Application for Planning Permission for Works or Extension to a Dwelling

Development: Erection of garden room in rear and internal alterations. (This application may affect the character and appearance of the Arundel Conservation Area and a Listed Building)

Location: 45 Tarrant Street Arundel BN18 9DJ

Proposed East Elevation
New Garden Room
1:50 @ A3

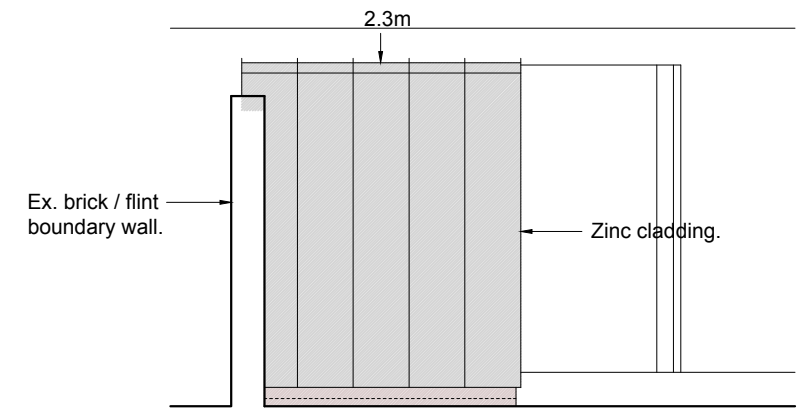
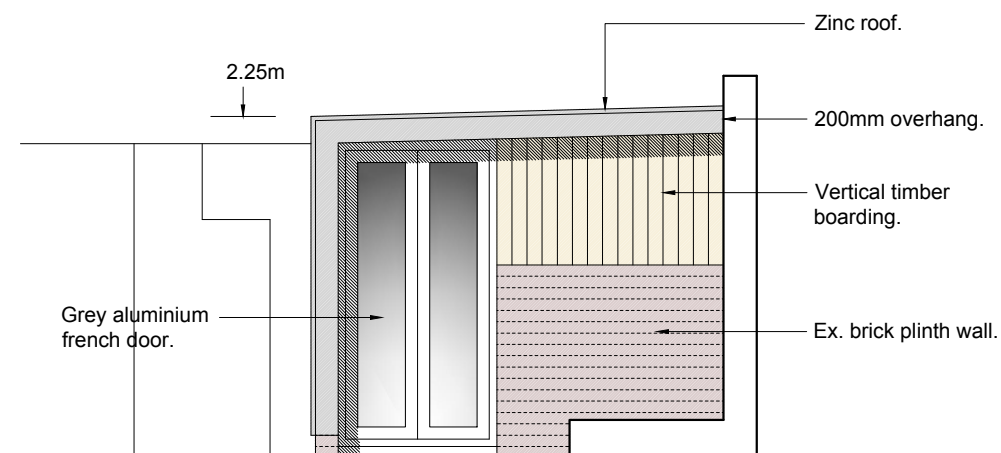
Proposed Plans: The 2.3m measurement listed on the proposed east elevation does not measure to scale. Please review and amend.
